Arun District Conservation Area Advisory Panel
c/o Civic Centre

Application No: LY/1/21/PL
Site Address: St Mary Magdalene's Church Church Lane Lyminster BN17 7QH
Description of works: Proposed new Klargestar below ground cesspool for existing Church WC facilities. This application may affect the setting of a listed building, may affect the character & appearance of the Lyminster Conservation Area & is in CIL Zone 3 (Zero Rated) as other development.

Thank you for your internet representation made on 14th March 2021 which has been recorded as no objection with the comments as follows:

Sketch plan showing location of cesspool storage tank
1:100

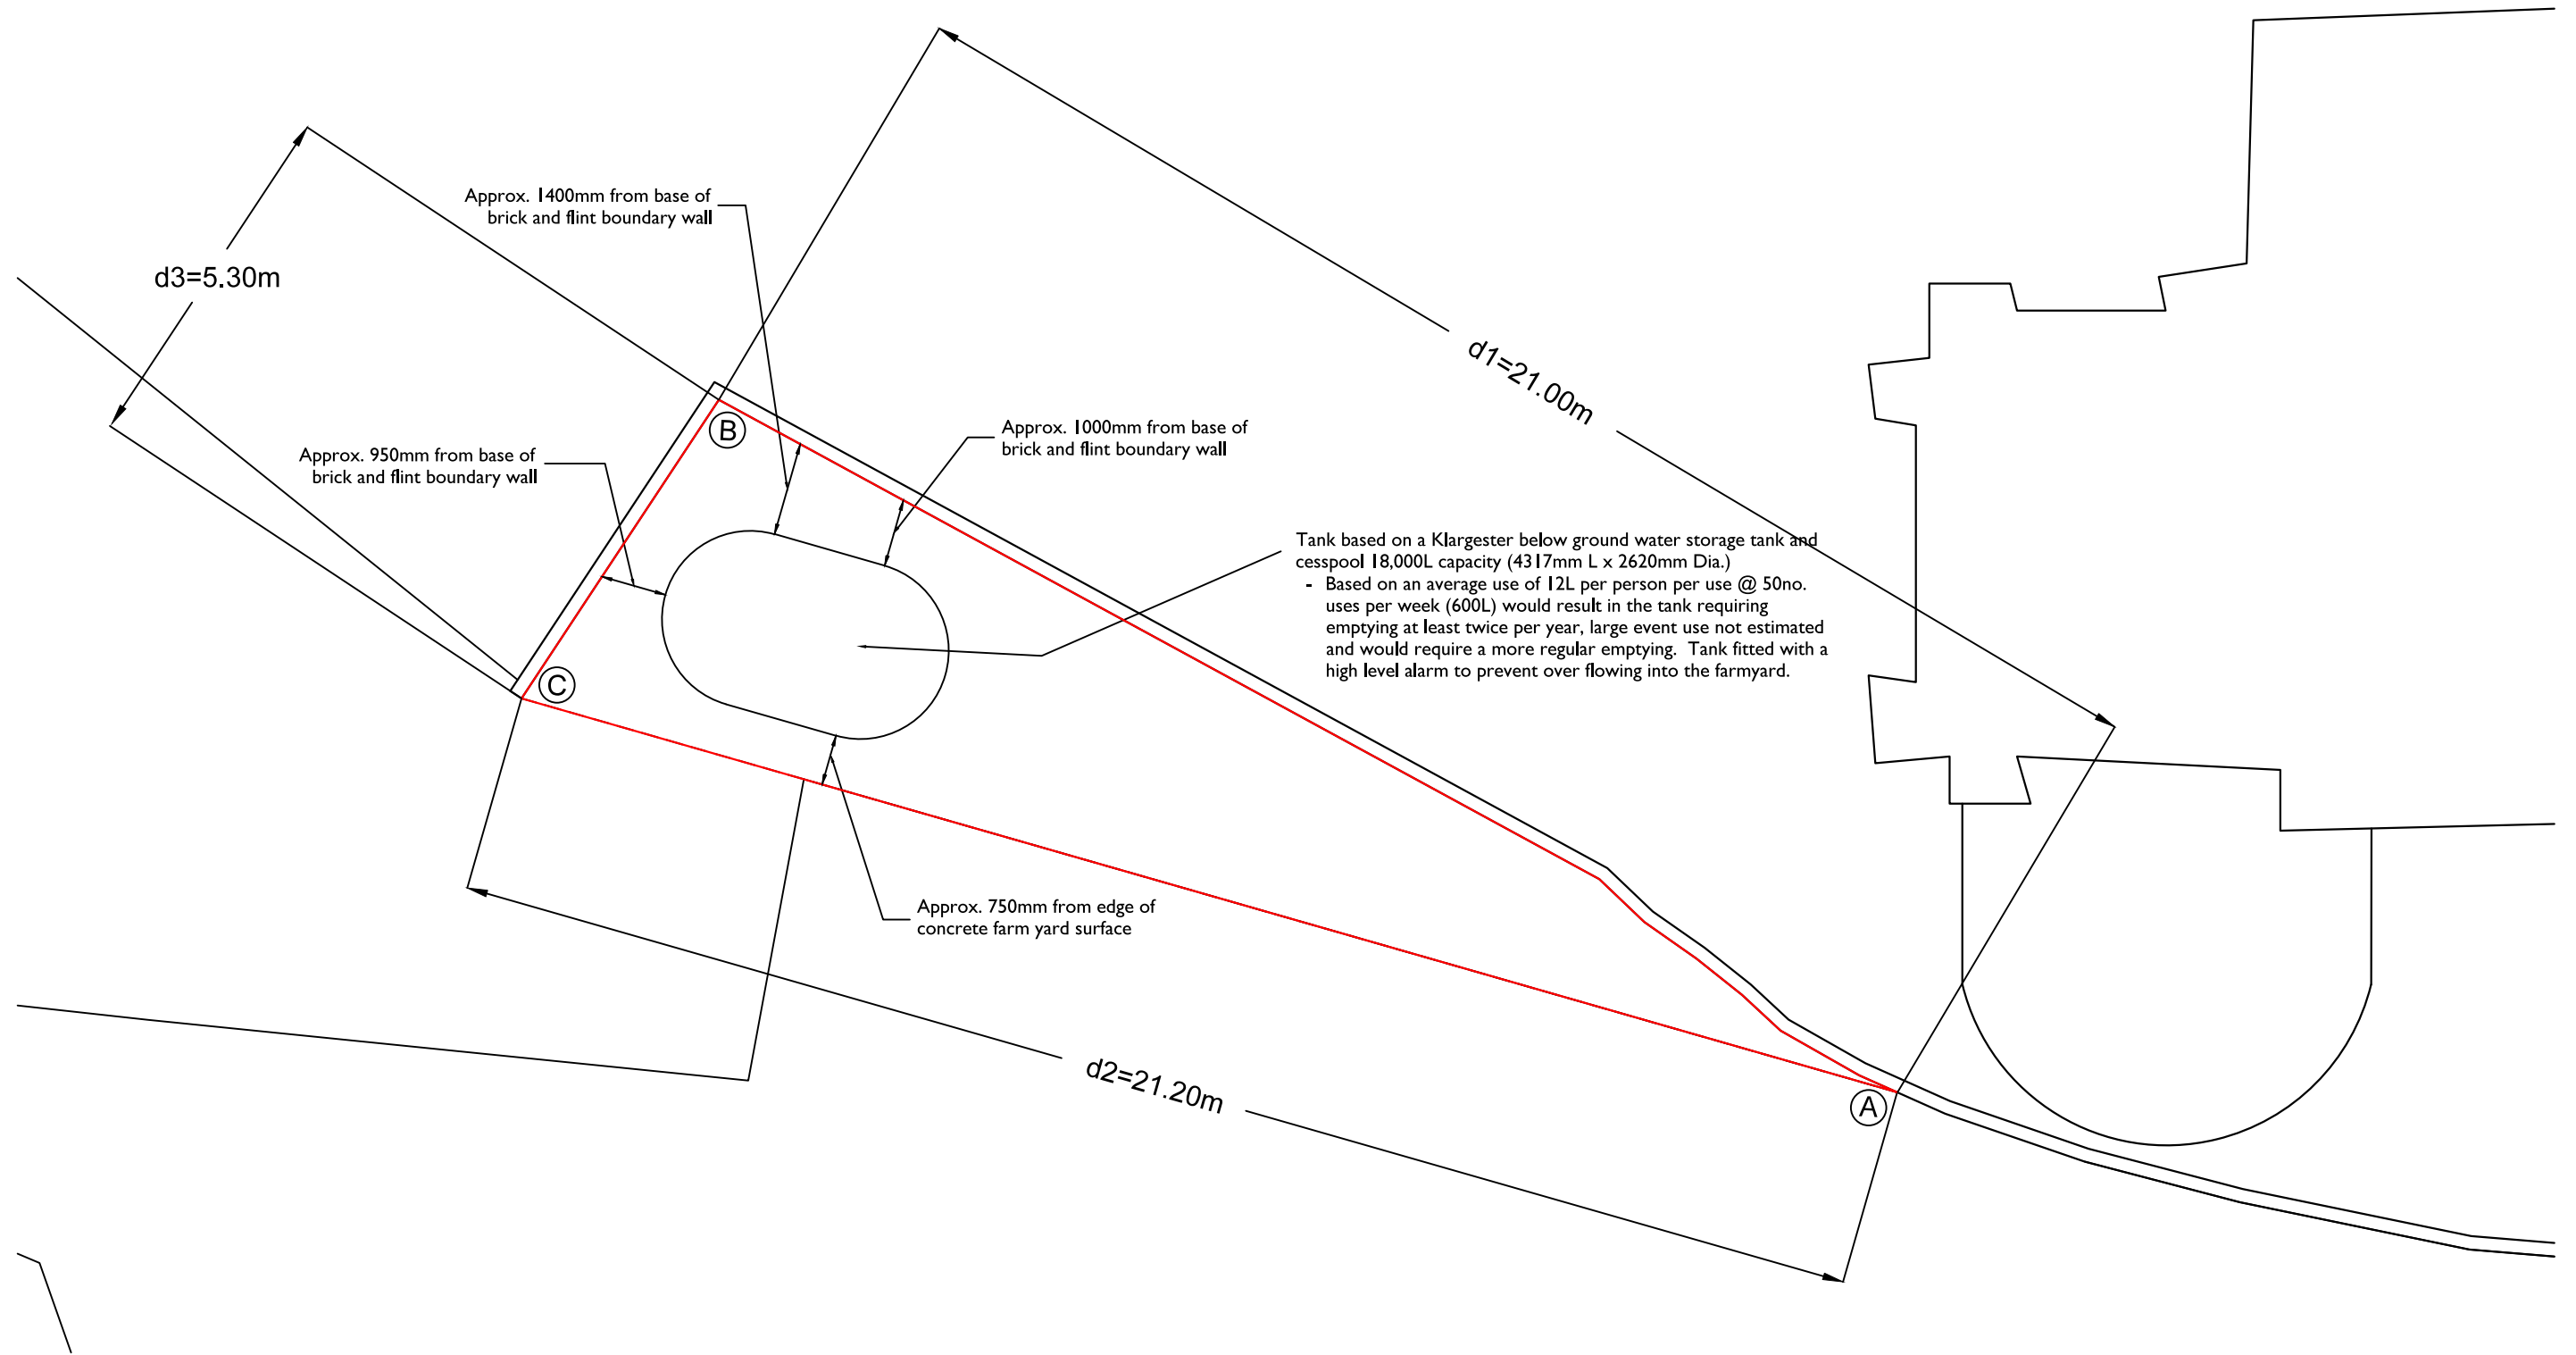
The proposed underground cesspool is intended to be sited outside of the existing curtilage of the grade 1 listed parish church. It will be sited to the north of modern farm buildings and there will be no harm to the character or appearance of the conservation area.

The Heritage Statement gives sound reasons why there should be no connection to the main drainage system. However, given the likely archaeological sensitivity of the location it is assumed that the County Archaeologist will need to be consulted in view of the excavation for the cesspool itself and the trenching required for its connection to the existing toilet facilities. Perhaps details of the route and depth of the trench should be provided and, if necessary, also an assessment of the effects, if any, of the proposed works on the existing church boundary wall.
